Arun District Council
Arun Civic Centre
Maltravers Road
Littlehampton
West Sussex BN17 5LF
Planning & Building Control General Enquiries
Tel: (01903) 737756 Fax: (01903) 730442
Dx: 57406 Littlehampton
Minicom: 01903 732765
e-mail: planning@arun.gov.uk
website: www.arun.gov.uk/planning

Application No: EP/124/20/HH
Site Address: Little Dormers 23 Upper Drive East Preston BN16 1QN
Description of works: New bay and porch skirt roof to the front elevation, and roof linked detached double garage.

Thank you for your internet representation made on 21st November 2020 which has been recorded as an objection with the comments as follows:

Garage Plans and Elevations -
Proposed

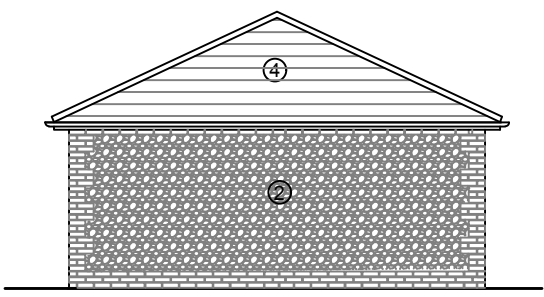
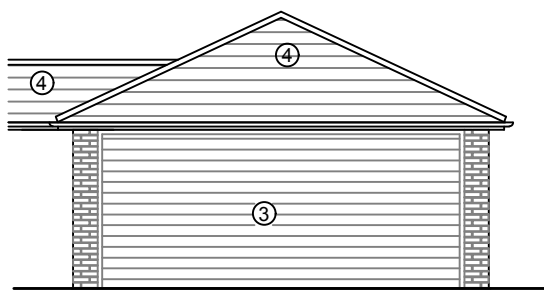
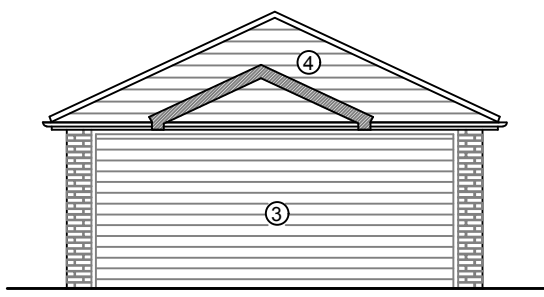
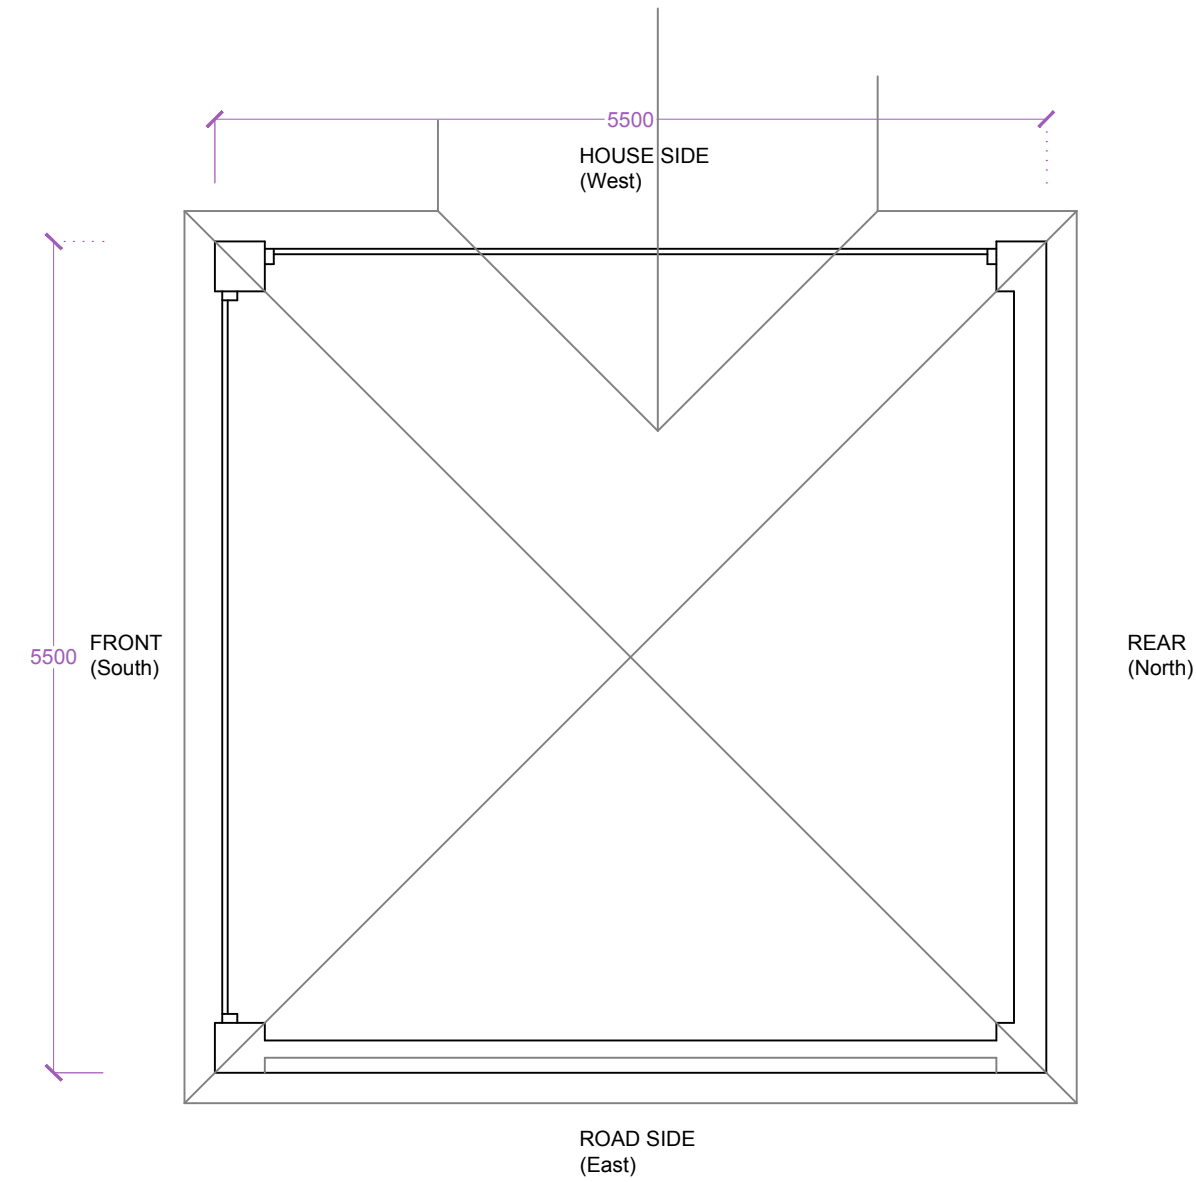
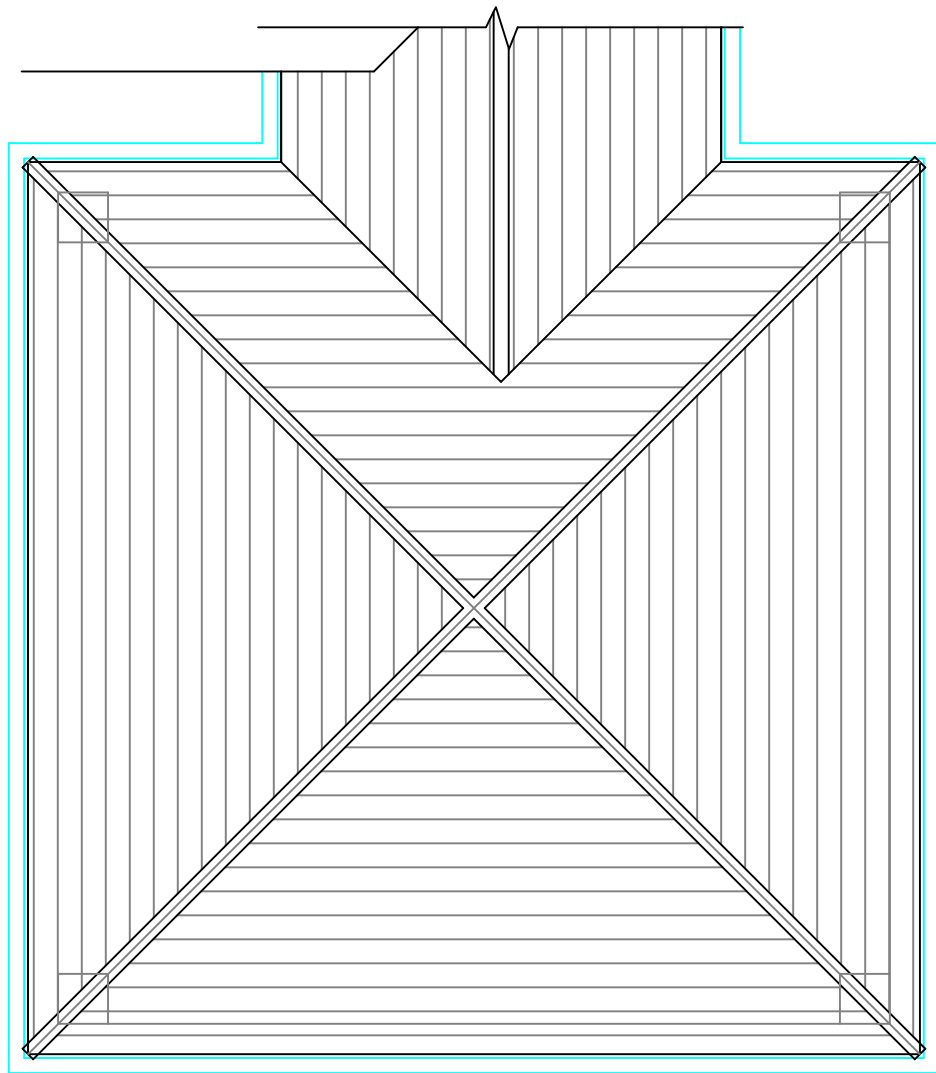
Sir/madam. I wish to object the proposal for the double garage of 23 upper drive I had a flyer from a neighbor about the planning application for the garage, and after going pass this property I feel this would not only be unsightly but oversized for this property, it would blockout the sunlight and views for next door at Number 25, also it would look out of character for this area
